27 August 2013

RE: LAKE MACQUARIE YACHT CLUB - SECTION 75W APPLICATION TO AMEND MAJOR PROJECT APPROVAL 08_0045

STAGE 1 SITE PLAN

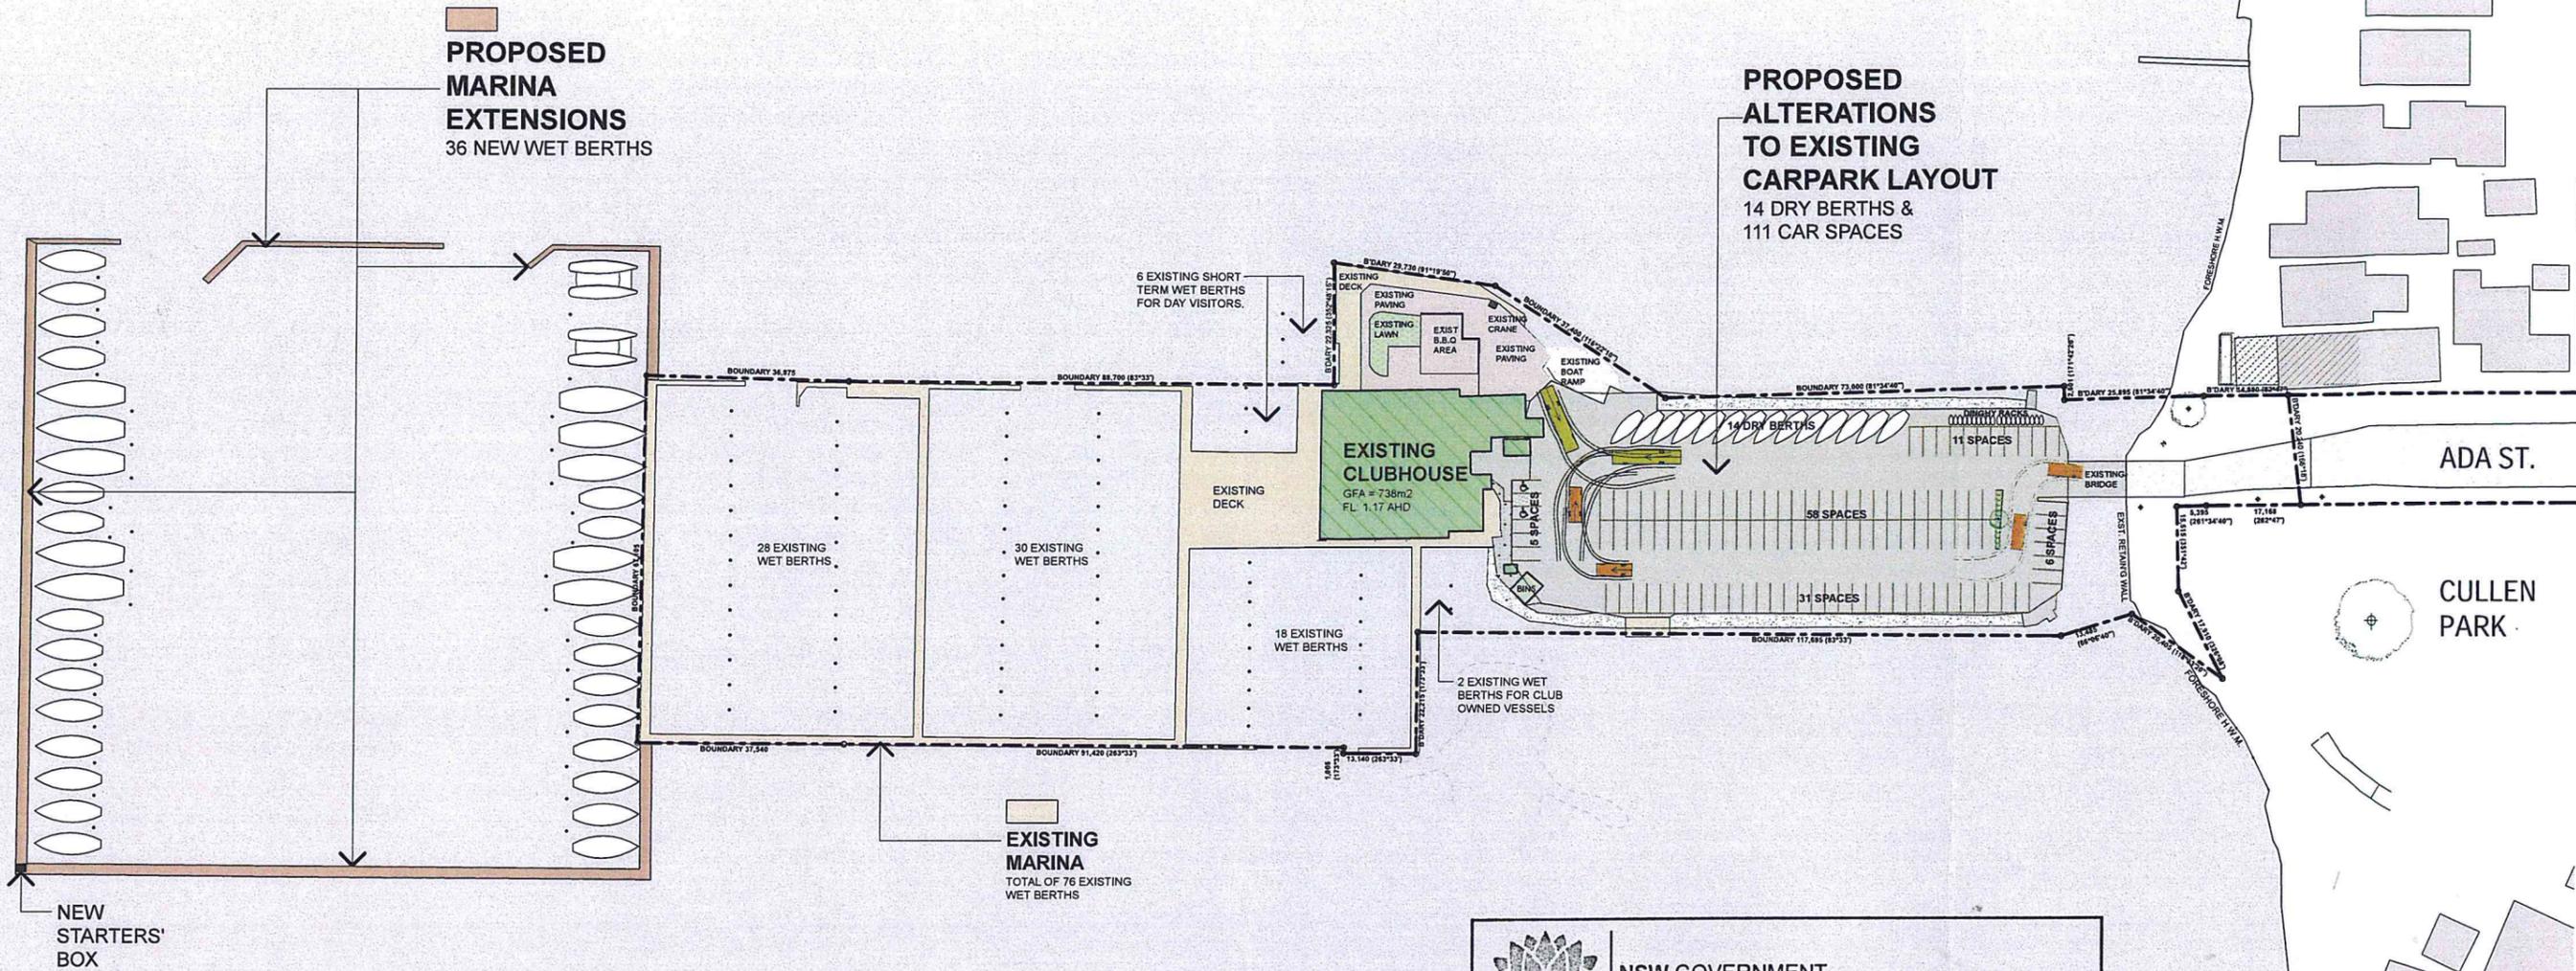
- Reduce the overall number of wet berths to be constructed at this stage from 148 (approved) to 112 whilst retaining 8 existing commercial swing moorings. The reduction would be achieved by deferring the construction of the central finger of the new marina to Stage 2;
- Provide 14 hardstand dry berths;
- Provide infrastructure and services associated with the proposed works;

- Reconfigure parking on the existing pontoon to accommodate 111 spaces (refer drawing at **Attachment 3**) based on the following parking requirements;

Project Component	Number of car spaces
Existing Club Building	50.2
New marina 112 wet berths @0.45 spaces per berth	50.4
New hardstand 14 dry berths @0.3 spaces per berth	4.2
8 swing moorings @0.45 spaces per mooring	3.6
8 short term wet berths	0
Total car spaces required	109
Total car spaces provided	111

PROJECT No 4000 PHASE DA [A] DRAWING No A102 REV C

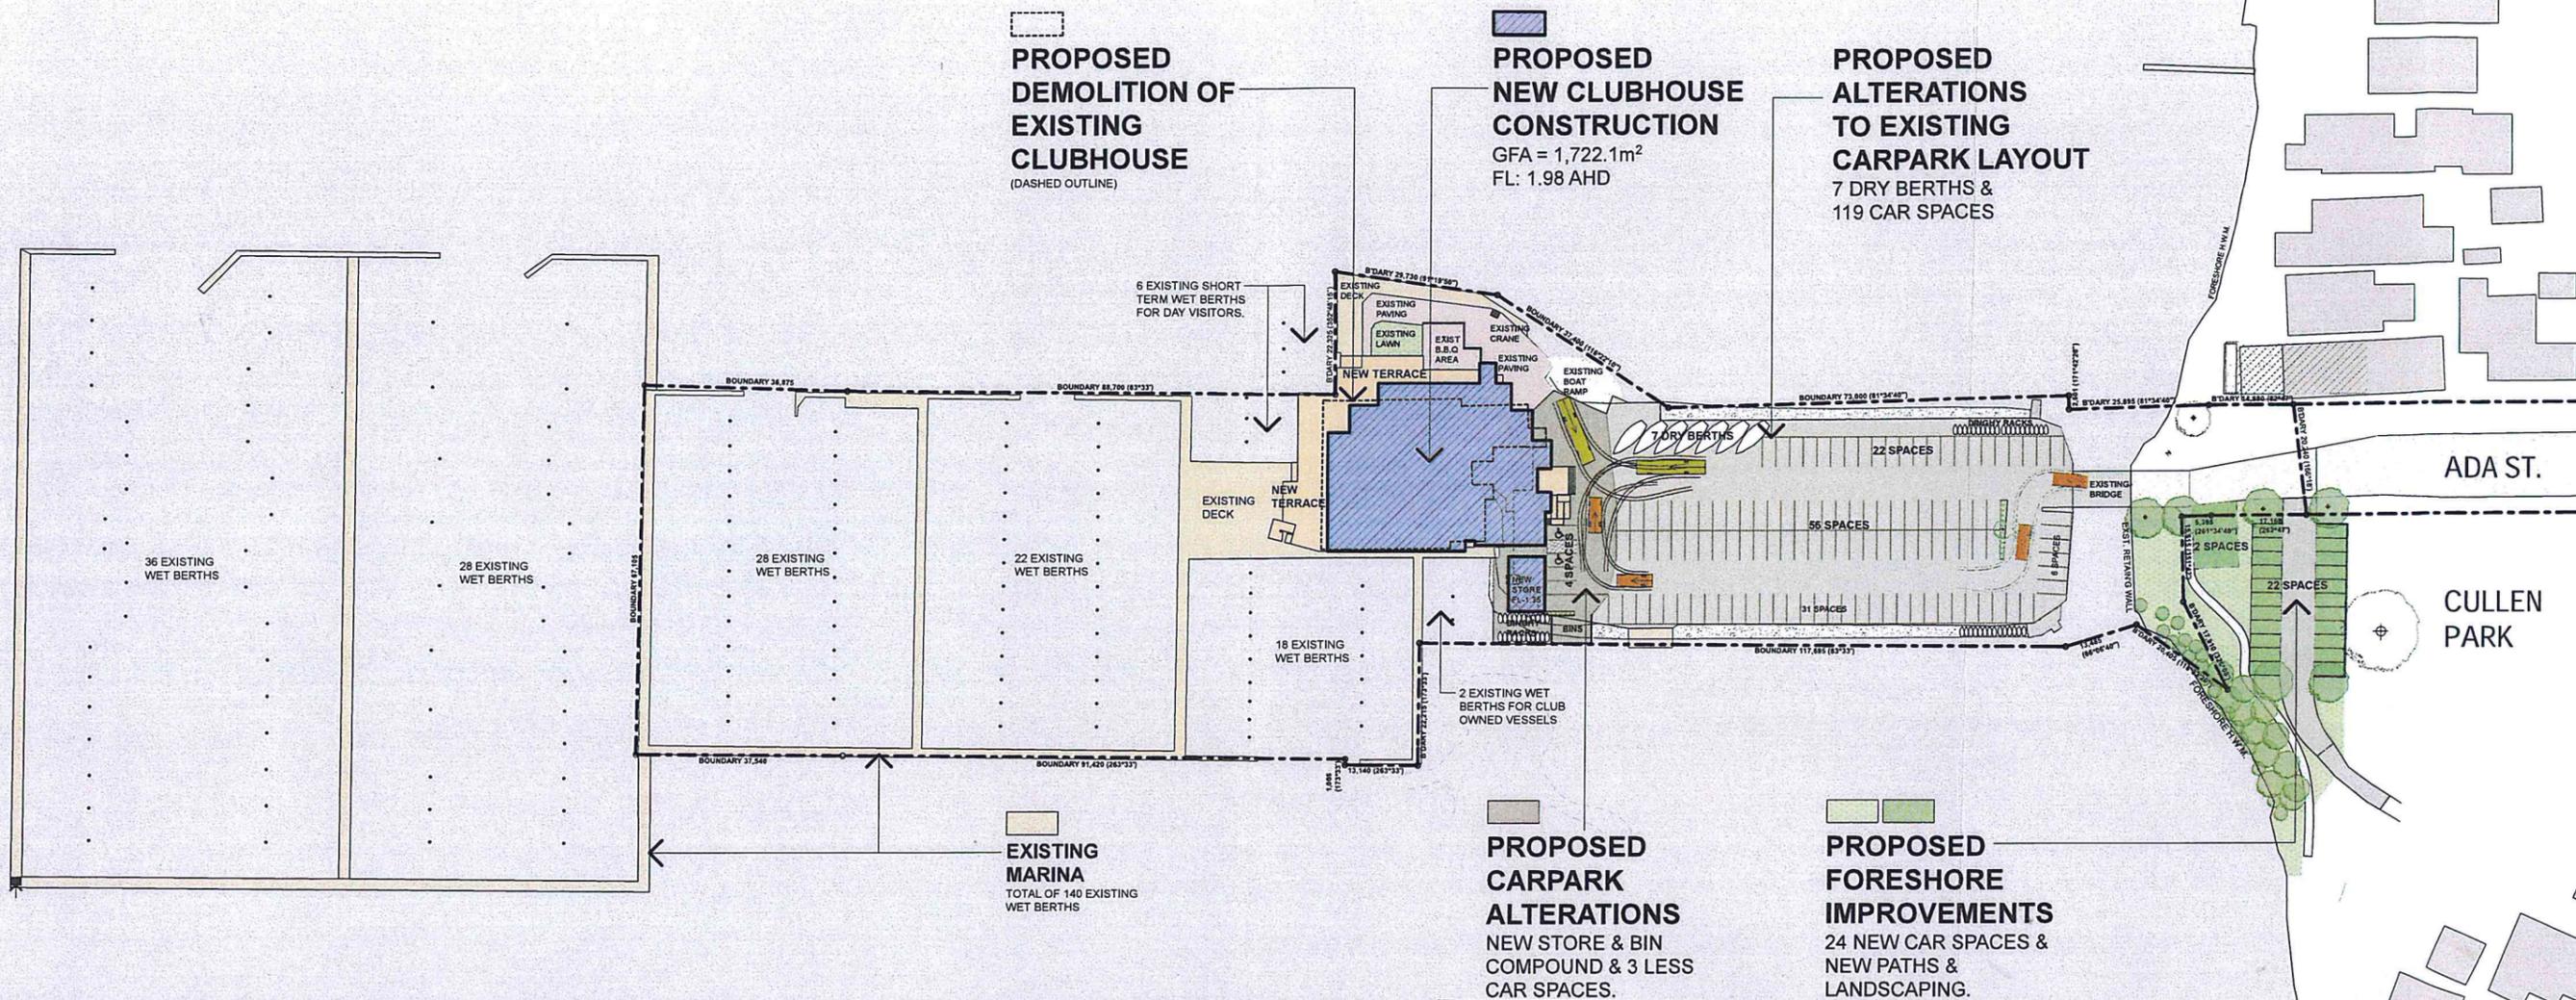
- Increase the number of wet berths to be constructed at this stage from 112 to 140 whilst retaining 8 existing commercial swing moorings. The increase would be achieved by constructing the central finger of the new marina;
- Reduce the number of hardstand dry berths from 14 to 8;
- Provide infrastructure and services associated with the proposed works;
- Reconfigure parking on the existing pontoon to accommodate 120 spaces (refer drawing at **Attachment 4**) based on the following parking requirements;

Project Component	Number of car spaces
Existing Club Building	50.2
New marina 140 wet berths @0.45 spaces per berth	63
Reduce hardstand dry berths to 8 @0.3 spaces per berth	2.4
8 swing moorings @0.45 spaces per mooring	3.6
8 short term wet berths	0
Total car spaces required	119.2
Total car spaces provided	120

DRAWING STAGE 3 SITE PLAN

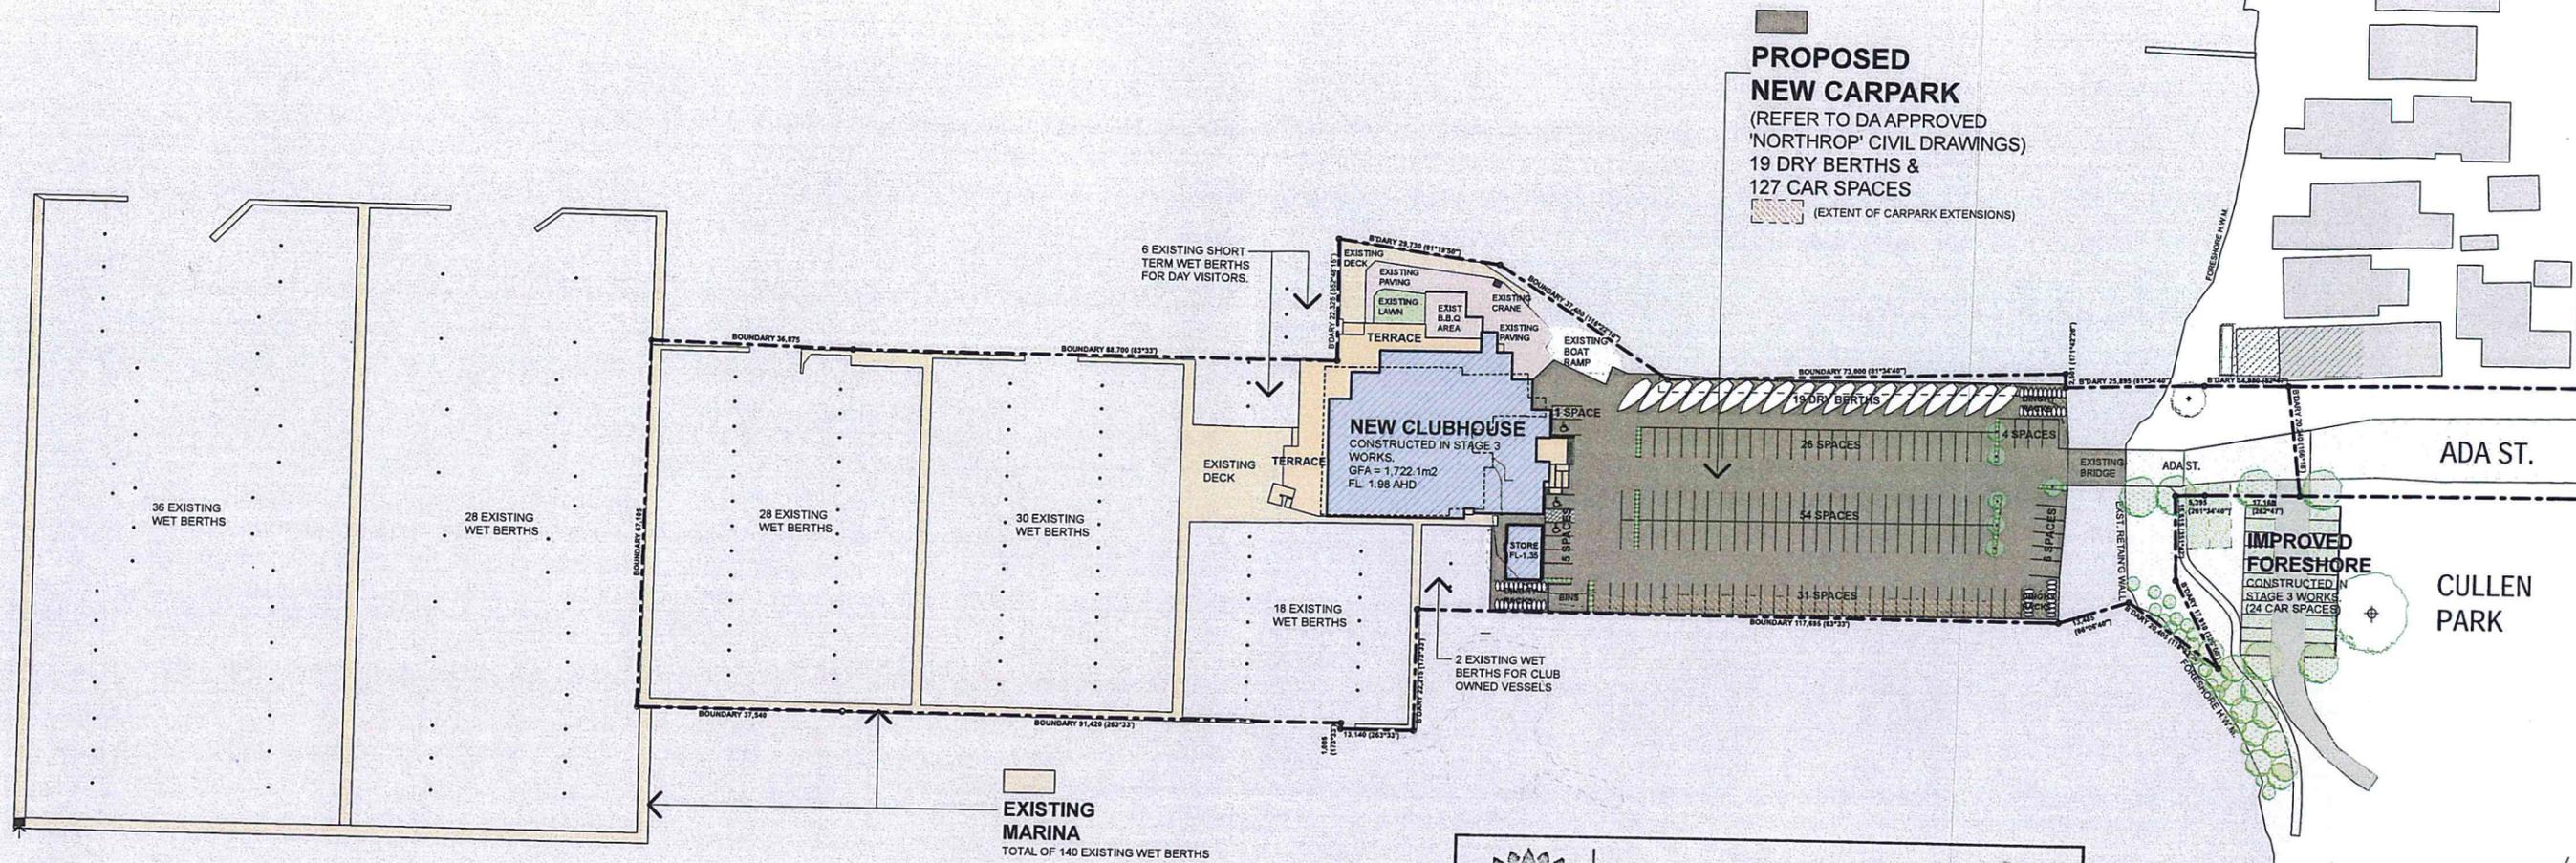
- Construct new club building;
- Carry out public domain improvements to Cullen Park including provision of formalised parking areas (24 spaces) and landscaping improvements;
- Carry out road works along Ada Street including provision of 18 additional car spaces bringing total number of car spaces provided to 162;
- Remove 8 swing moorings;
- Total number of car spaces required to be provided is as follows (refer drawing at **Attachment 5**):

Project Component	Number of car spaces
New Club Building	109
New marina 140 wet berths @0.45 spaces per berth	63
Reduce hardstand dry berths to 7 @0.3 spaces per berth	2.1
8 short term wet berths	0
Total car spaces required	174
Total car spaces provided	144 (162 including Ada Street)

It should be noted that Drawing A10 Revision C (existing approval) shows a total of 151 car spaces, including 127 spaces located on the existing pontoon as well as 22 car spaces and 2 trailer spaces located on at Cullen Park foreshore reserve. This resulted in an agreed parking deficiency (excluding Ada Street) of 31 spaces.

The overall net effect of the proposed change at the end of Stage 3 is a reduction of 12 berths (requiring $12 \times 0.45 = 5.4$ car parks) and 8 swing moorings (requiring $8 \times 0.45 = 3.6$ car parks) or 9 car spaces in total. The overall number of car spaces is proposed to be reduced by 7 from 169 to 162.
